From: PAUL BAXTER [REDACTED]
Sent: 17 October 2011 15:20
To: Katherine Rawlins
Subject: Re: AW/216/11/T

From: Katherine Rawlins <Katherine.Rawlins@arun.gov.uk>
 Subject: AW/216/11/T
 To: [REDACTED]
 Date: Friday, 14 October, 2011, 12:25

I refer to the above application for various tree works.

Photo 1 Holm oak on grass verge
outside No. 1 The Drive

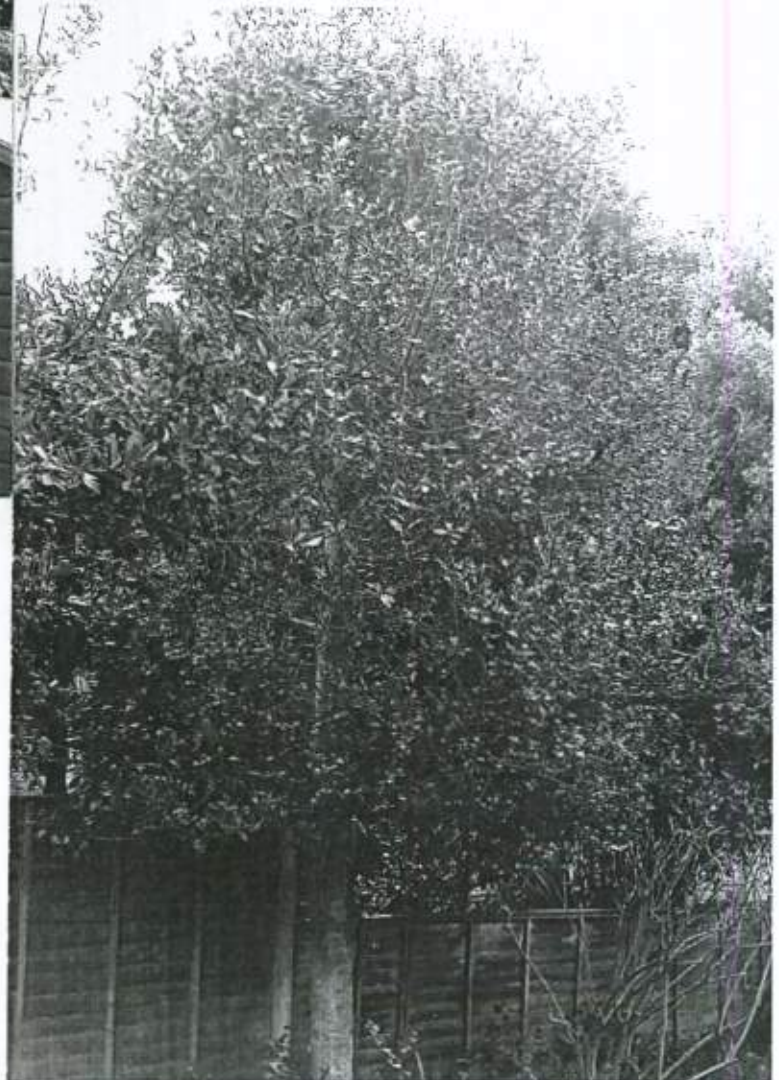
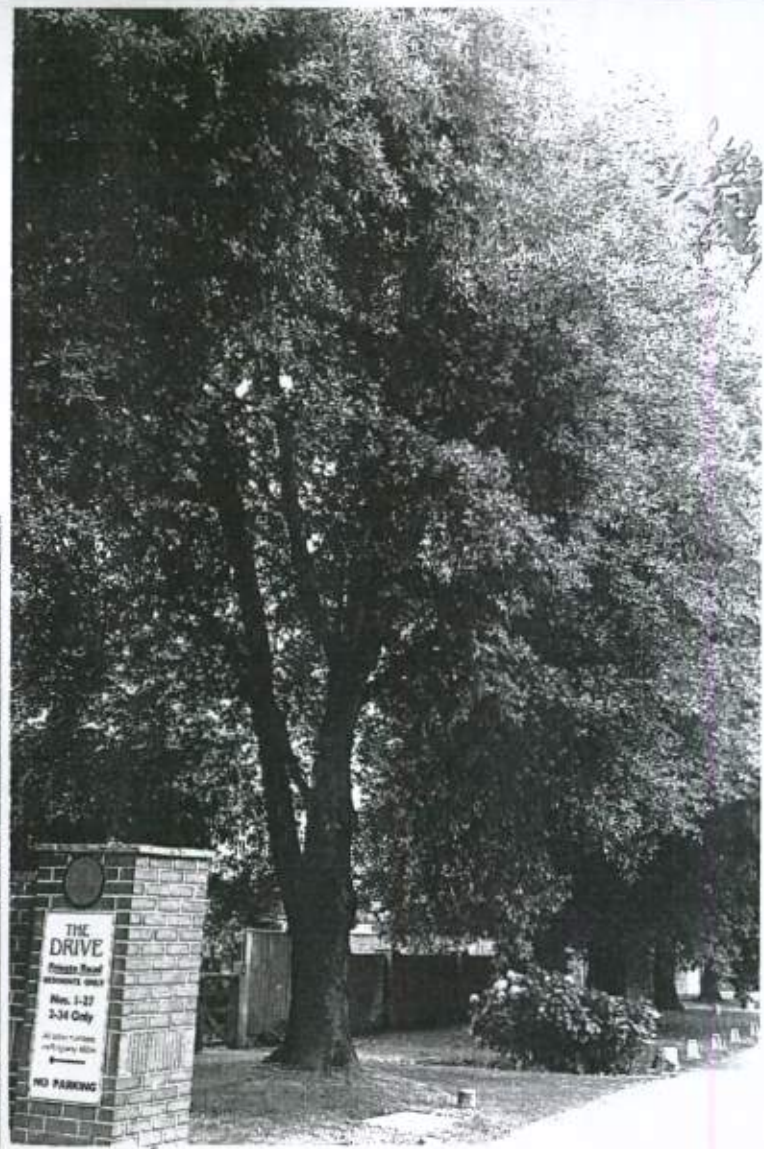
There are 3No. Evergreen Oaks along Barrack Lane in a line from the northeast to the southwest. The application refers to these as 2No Holm Oaks to the west of the drive entrance and a large Holm Oak standing on the roadside and north of the above cypress. Considering the slightly defective main stem and branching structure, the reduction works to the Holm Oaks (of 25%) are acceptable and would specify a maximum amount of 2 metres to be removed from the top growth and 1 metre from the side growth. No reason has been provided for the 4 metre crown lift and would therefore allow a crown raise of 2.5 metres. The reduction of the 3 Leyland Cypress and 1 Eucalyptus for the reasons provided in the surgeons report is acceptable.

Further to our telephone conversation today, this is to confirm that the recommendations are acceptable to us. We look forward to receiving the Council's formal approval in due course.
